SCOPING OPINION

Proposed Tavistock to Bere Alston railway reinstatement and associated trails

December 2014

This report sets out the Secretary of State's opinion on the basis of the information provided in the Devon County Council ('the applicant') report entitled Environmental Impact Assessment Screening and Scoping Report (October 2014) ('the Scoping Report'). The Opinion can only reflect the proposals as currently described by the applicant.

Locations of search areas for telecommunication masts

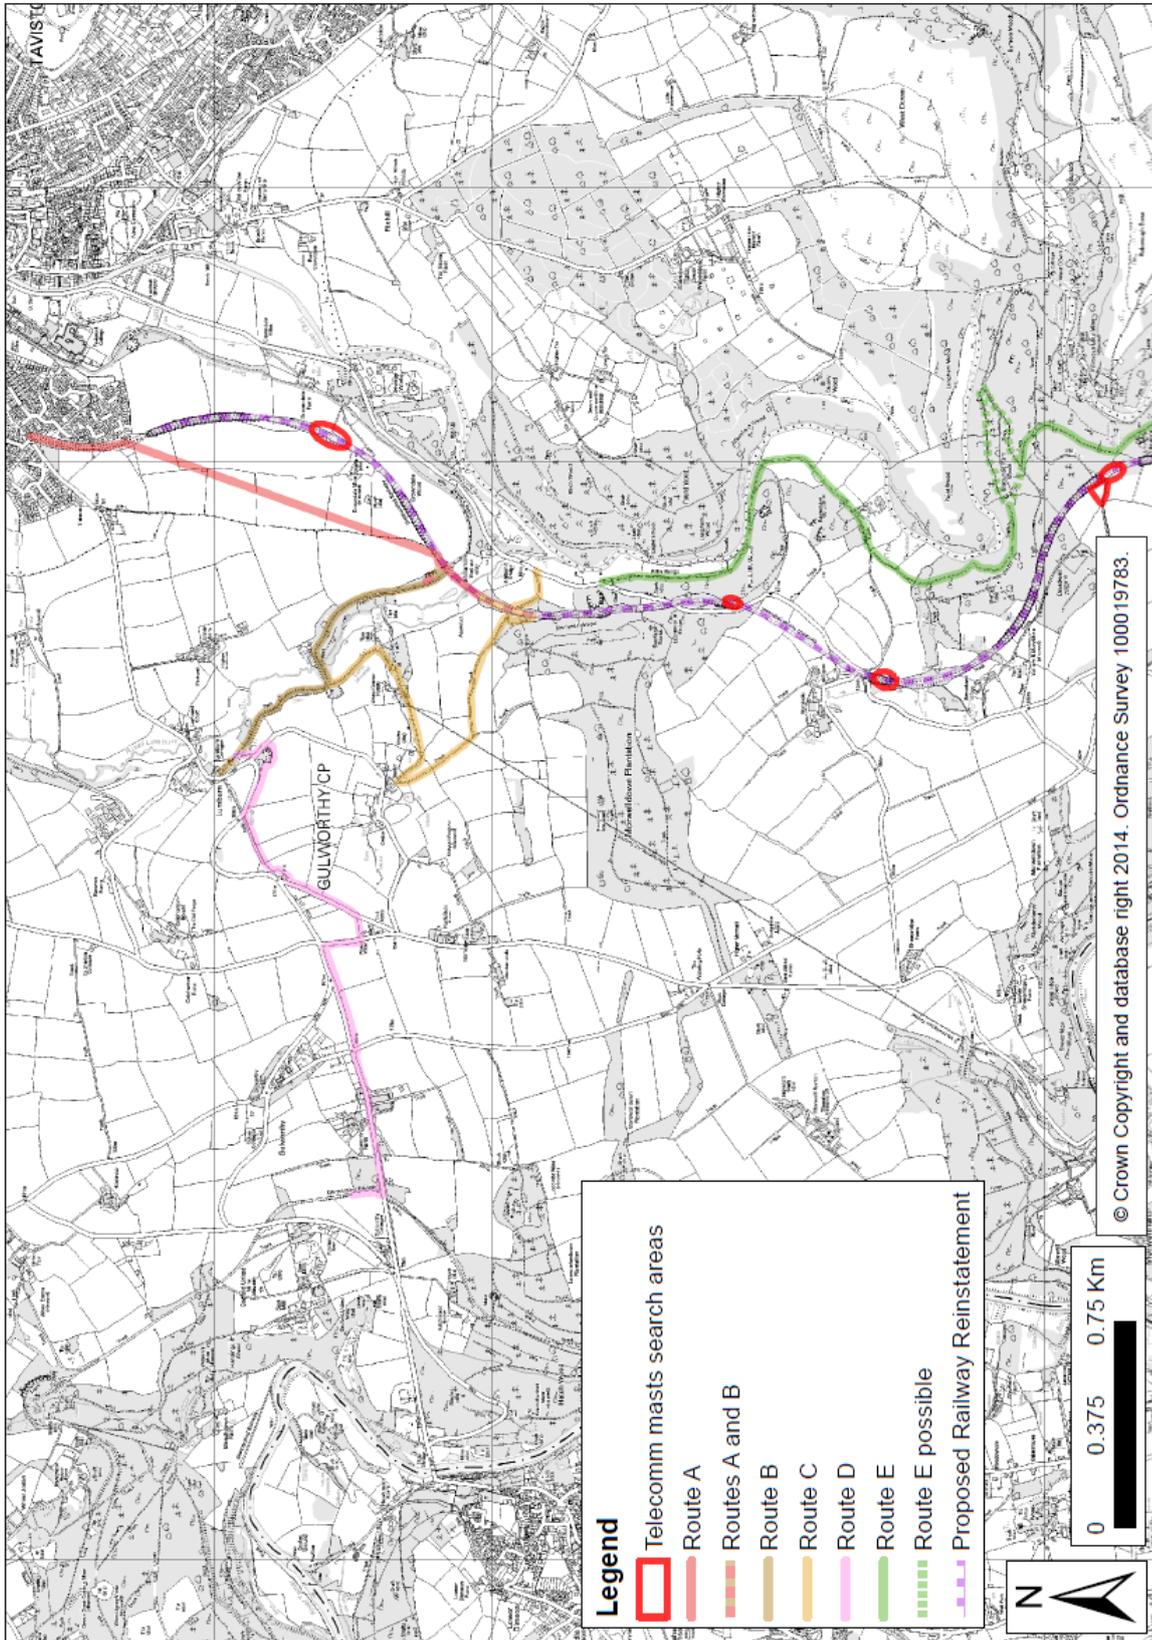
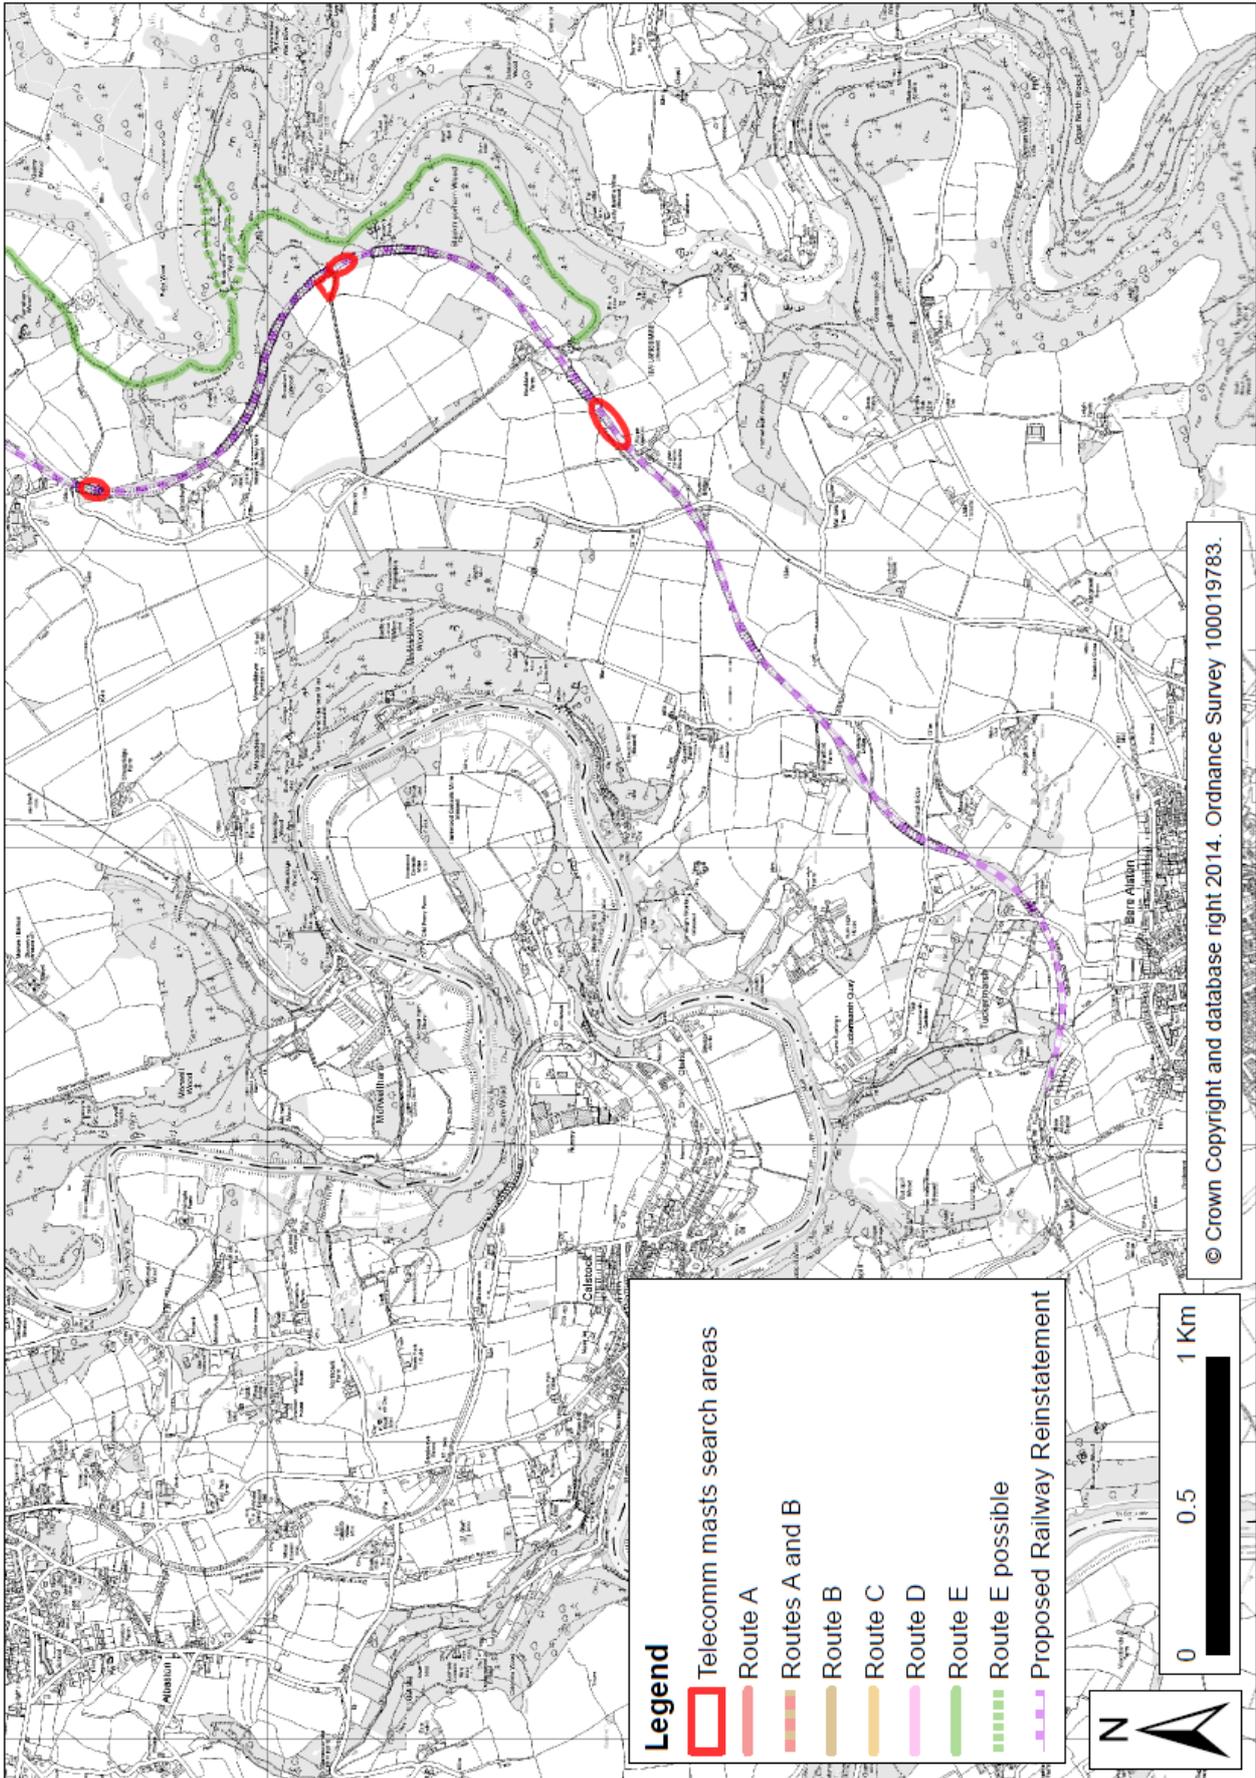
- 2.40 The locations of the four proposed telecommunications masts should be defined. If this is not possible, all potential locations should be fully described and assessed as part of the EIA.
